KITTITAS COUNTY COMMUNITY DEVELOPMENT SERVICES

December 22nd, 2017

RE: Swauk Valley Plat (LP-17-00007) – Request for additional information

**SHEET 1**

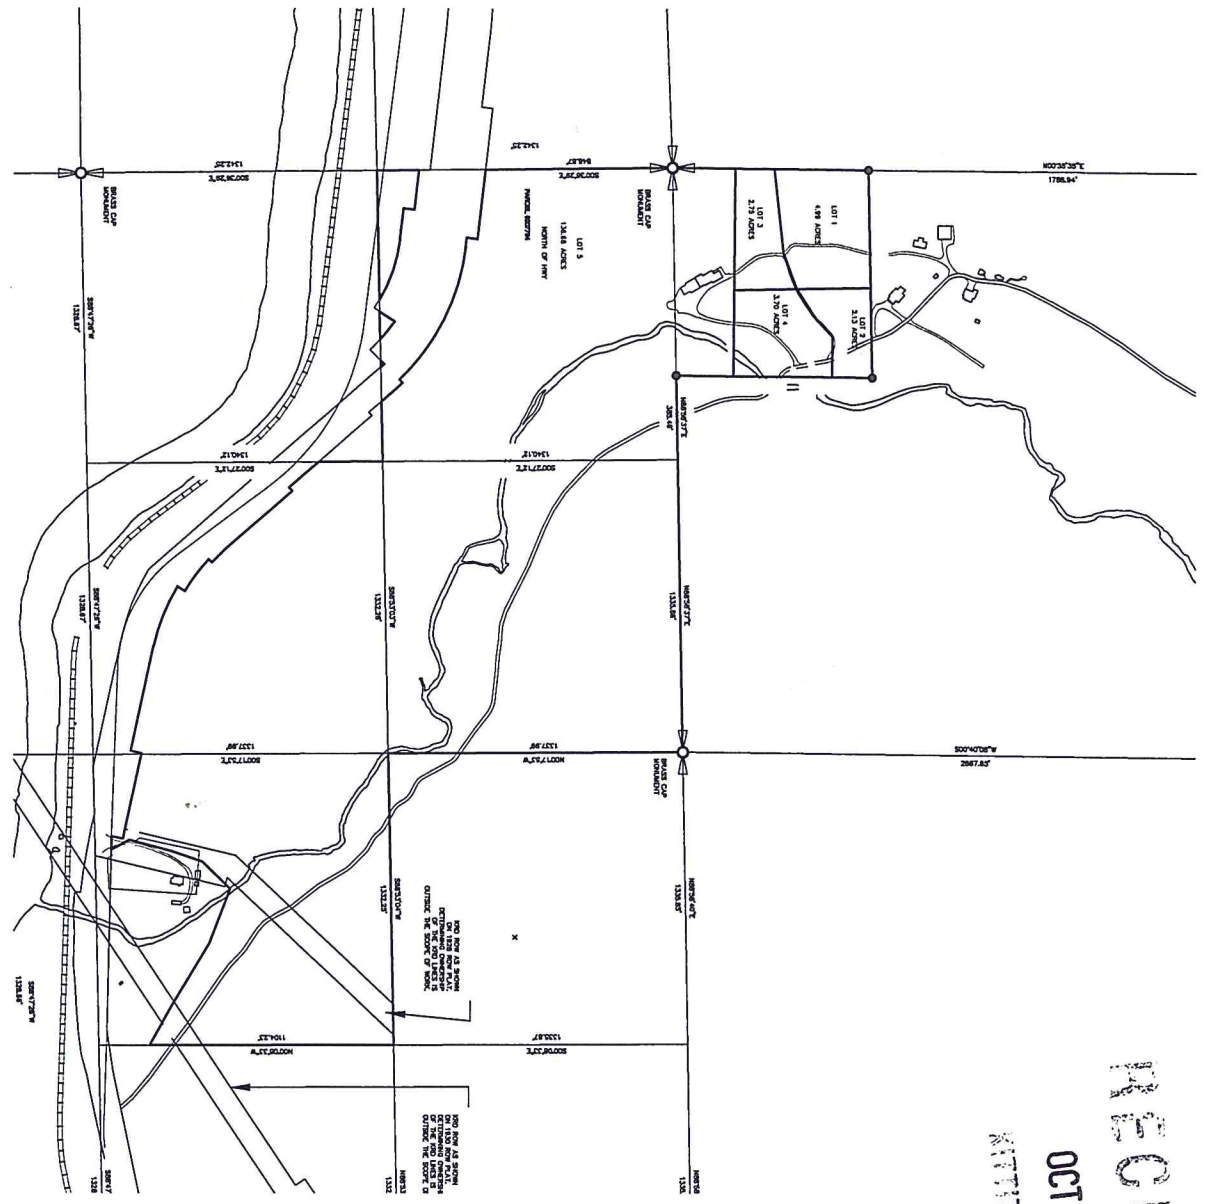
- 1) The farmstead parcel must be adjusted such that it is not larger than 10 acres, in order to meet KCC 16.09.060(2)(a).
- 2) Building envelopes must be shown on the plat, along with a narrative showing justification of location and size of building envelopes, consistent with KCC16.09.060(2)(b).
- 3) A completed SEPA checklist and review fees must be submitted.

As currently proposed, the plat shows a farmstead on a 138.68 acre lot, with four other lots ranging from 2.13 to 4.99 acres, without building envelopes. The plat was submitted as a short plat.

As currently proposed, the plat divides parcel # 207734 into 5 total parcels. Under these provisions, the proposal fits the definition of a long plat under County Code and as such is not exempt from SEPA review.
